# OXFORDSHIRE COUNTY COUNCIL'S RESPONSE TO CONSULTATION ON THE FOLLOWING DEVELOPMENT PROPOSAL

**Application no:** 22/01144/F

**Proposal:** Full planning application for the erection of a new high quality combined research, development and production facility comprising of Class B2 floorspace and ancillary office floorspace with associated infrastructure including: formation of signal-controlled vehicular access to the A41 and repositioning of existing bus stops; ancillary workshops; staff gym and canteen; security gate house; a building for use as an energy centre (details of the energy generation reserved for future approval); loading bays; service yard; waste management area; external plant; vehicle parking; landscaping including permanent landscaped mounds; sustainable drainage details; together with the demolition of existing agricultural buildings within the red line boundary; and the realignment of an existing watercourse

**Location:** South West Of Grange Farm Street Through Little Chesterton Chesterton

Title  
**PROPOSED CULVERTED WATERCOURSE DETAILS.**

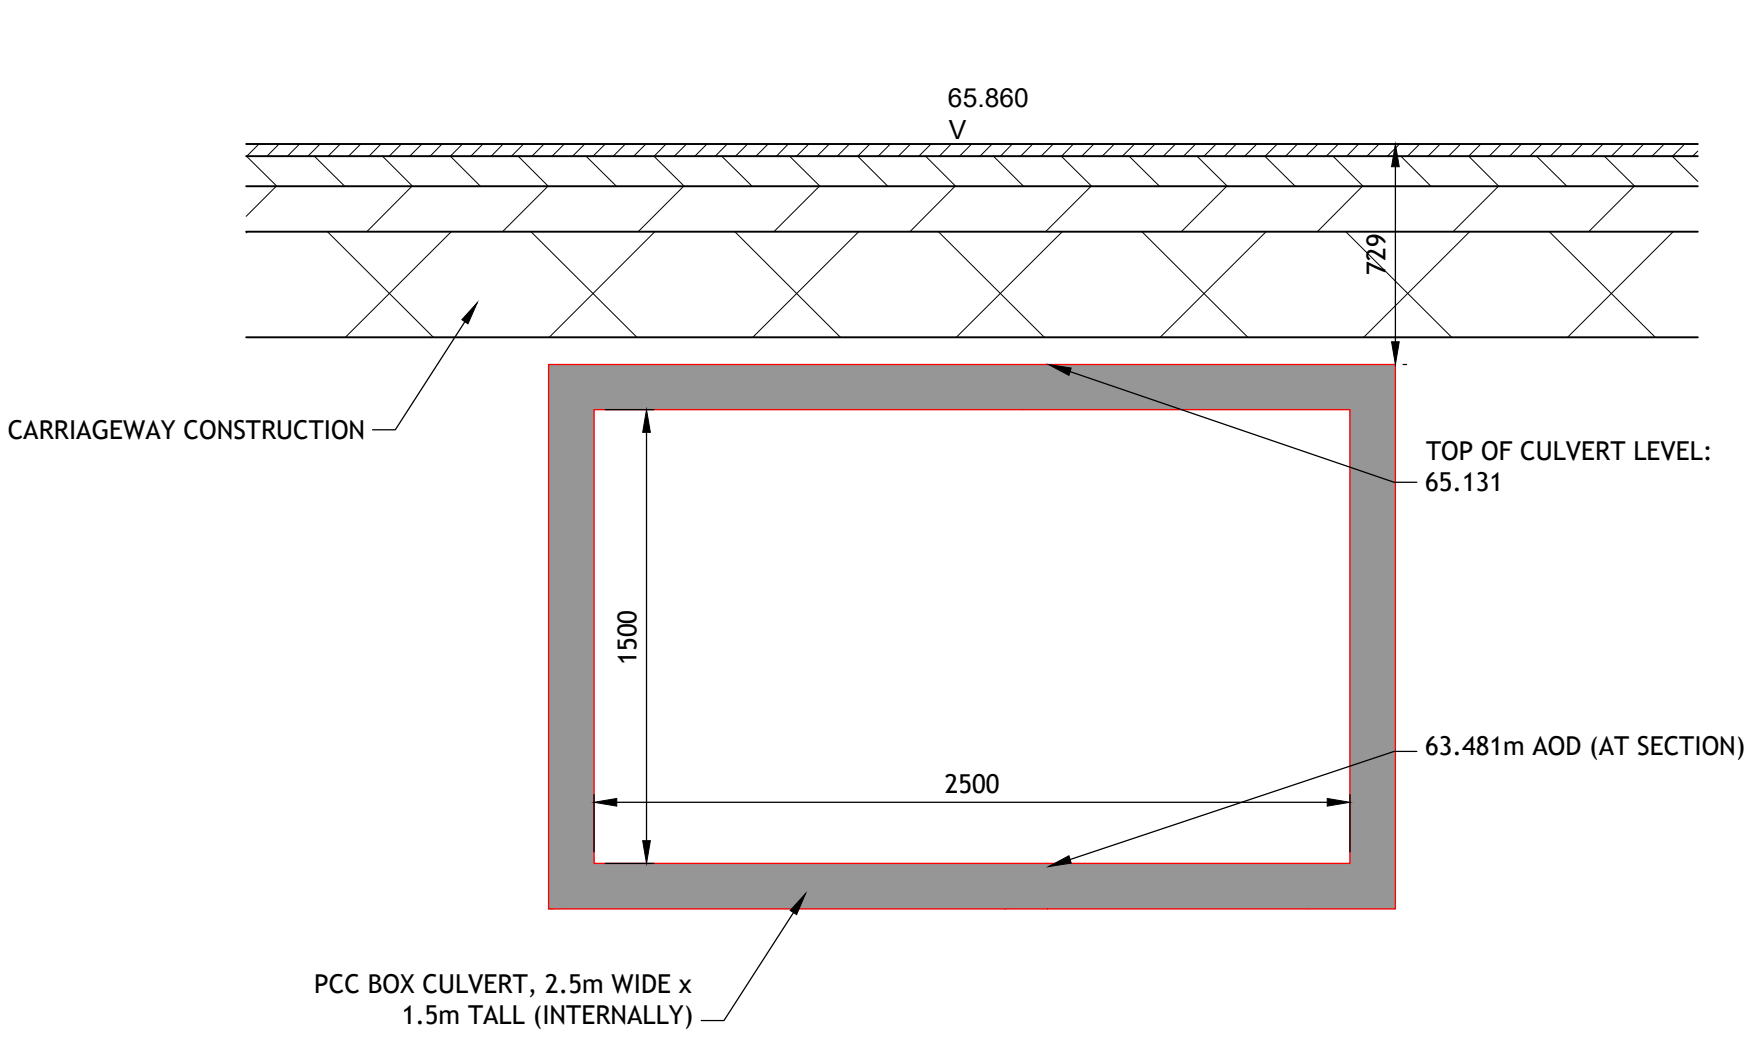
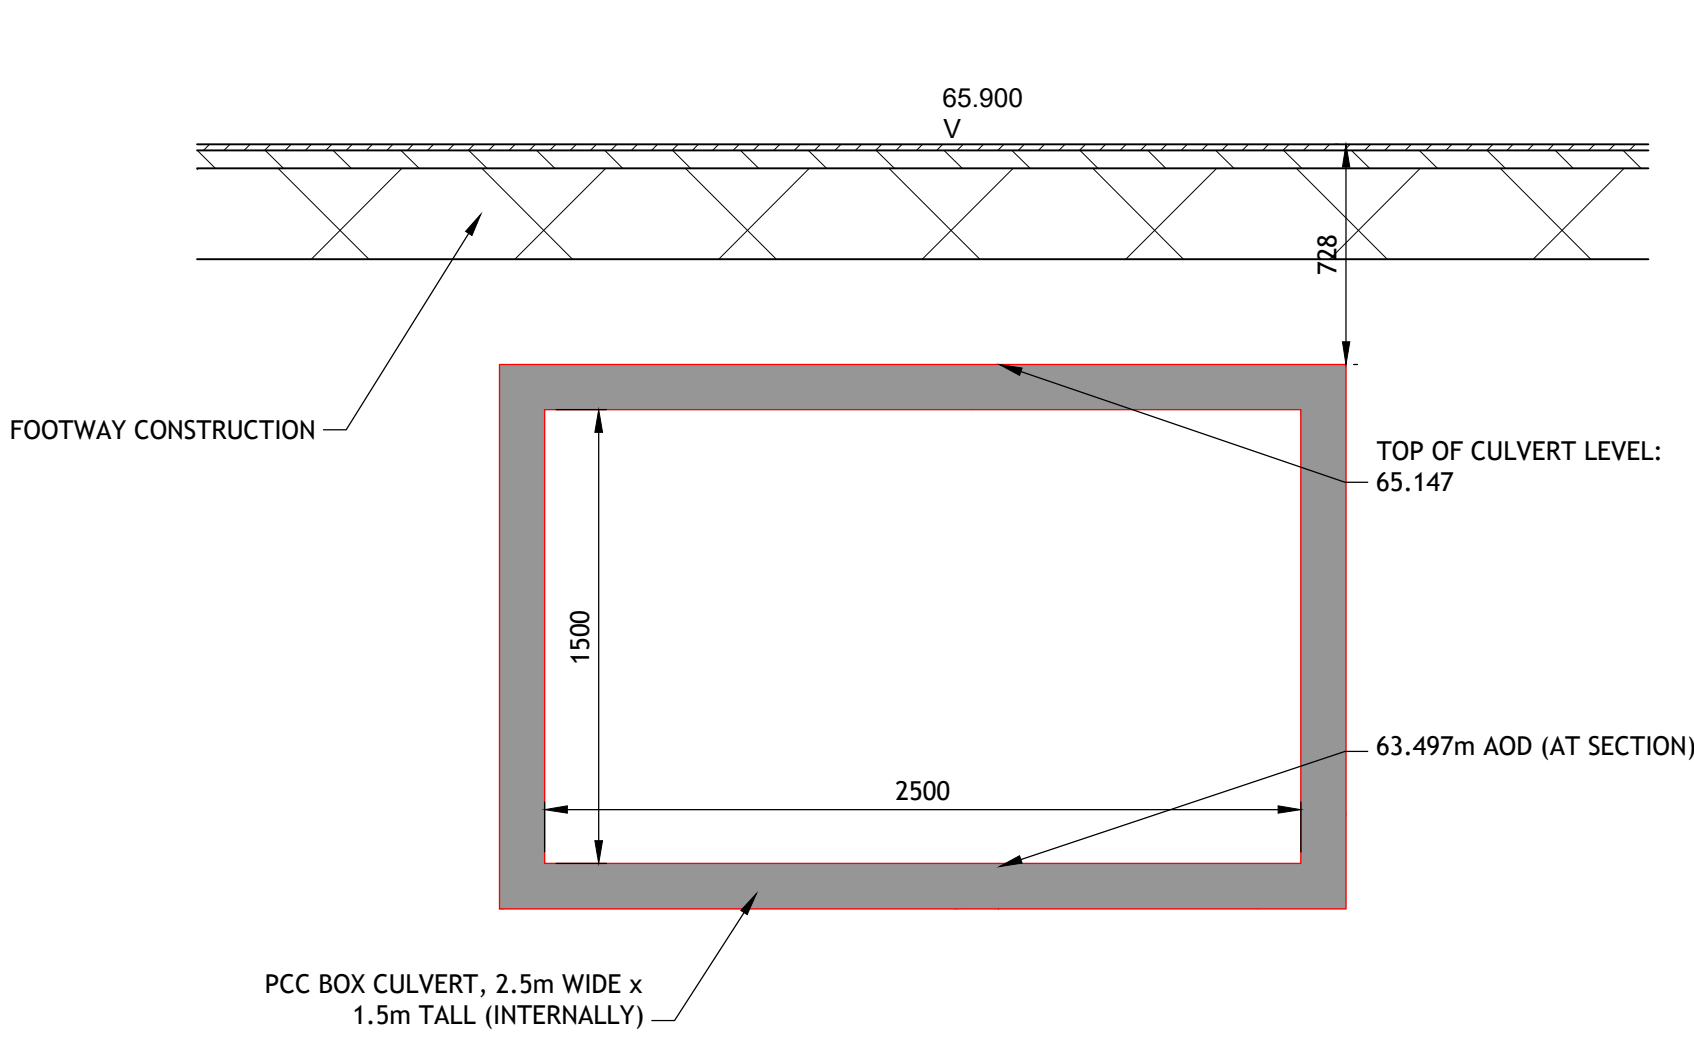
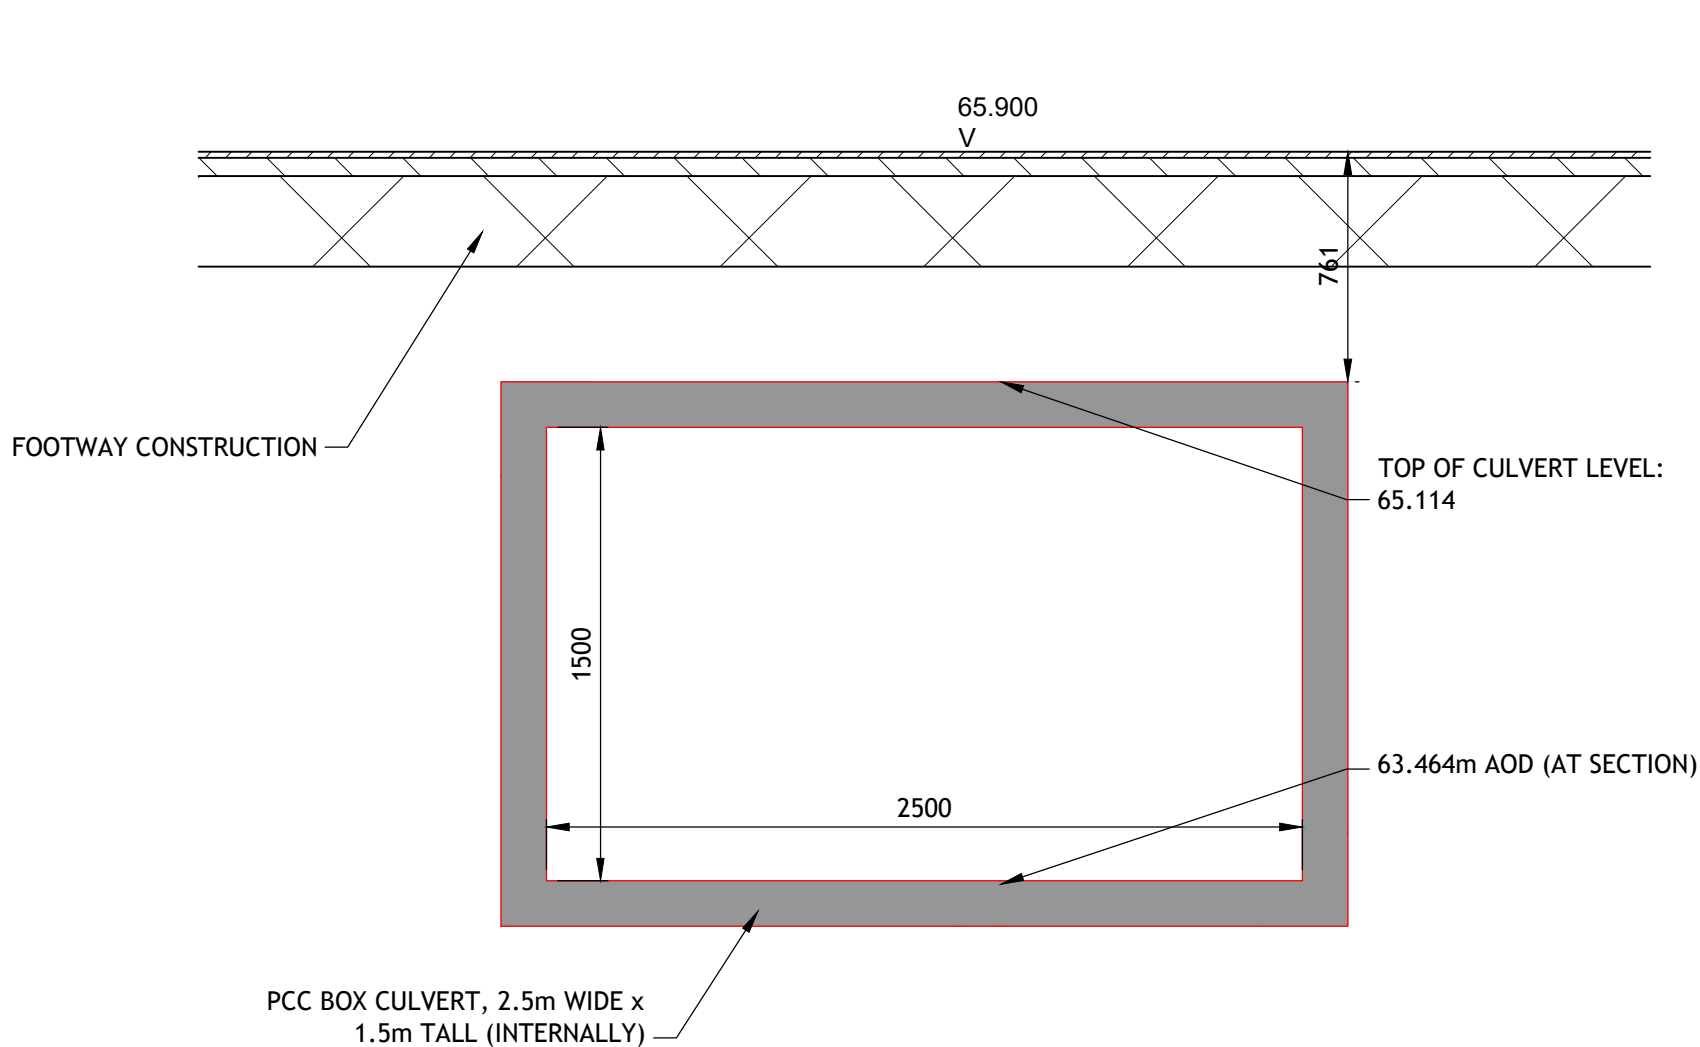
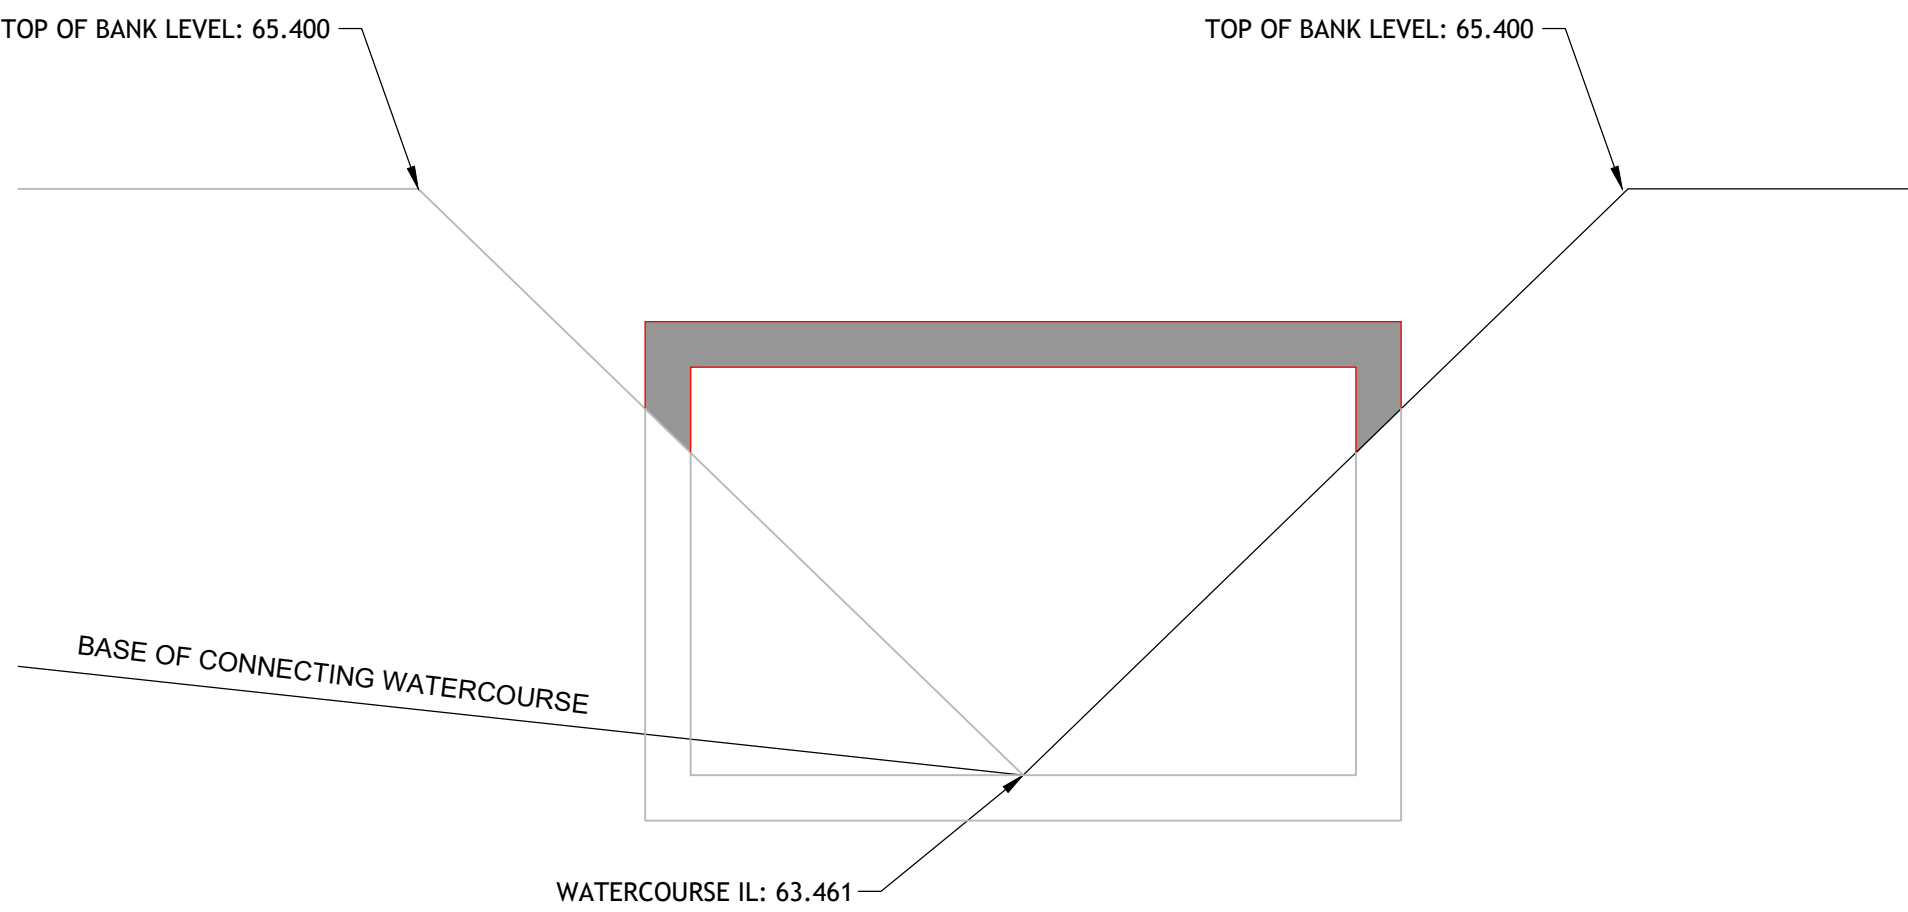
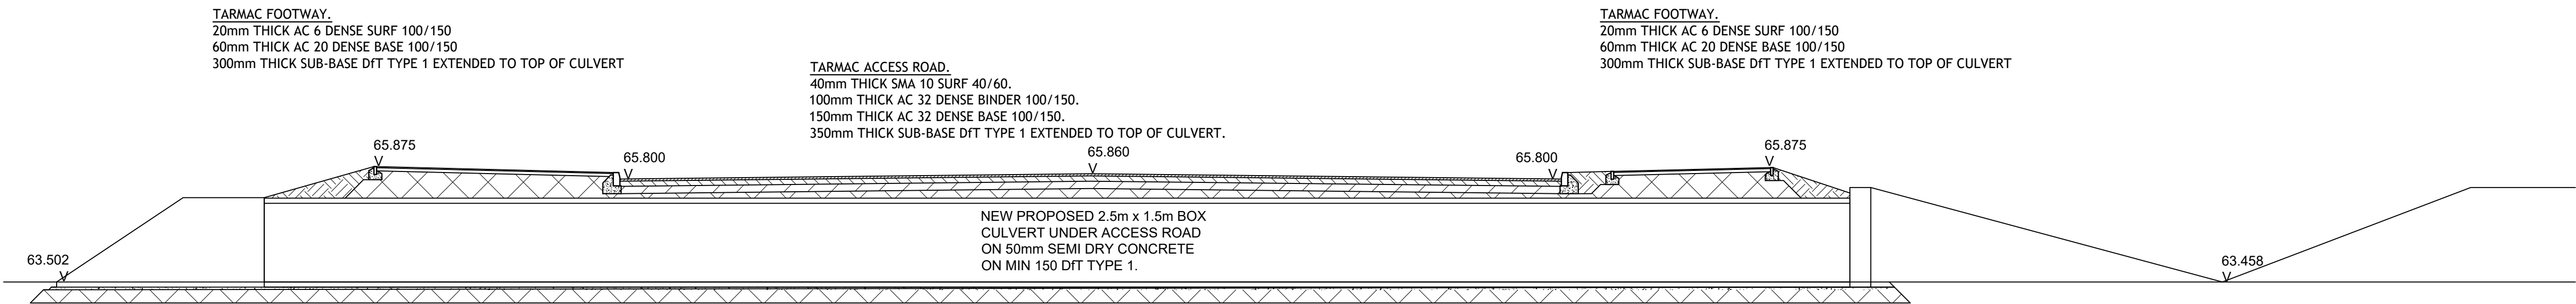
Provide the culvert size and culvert condition.
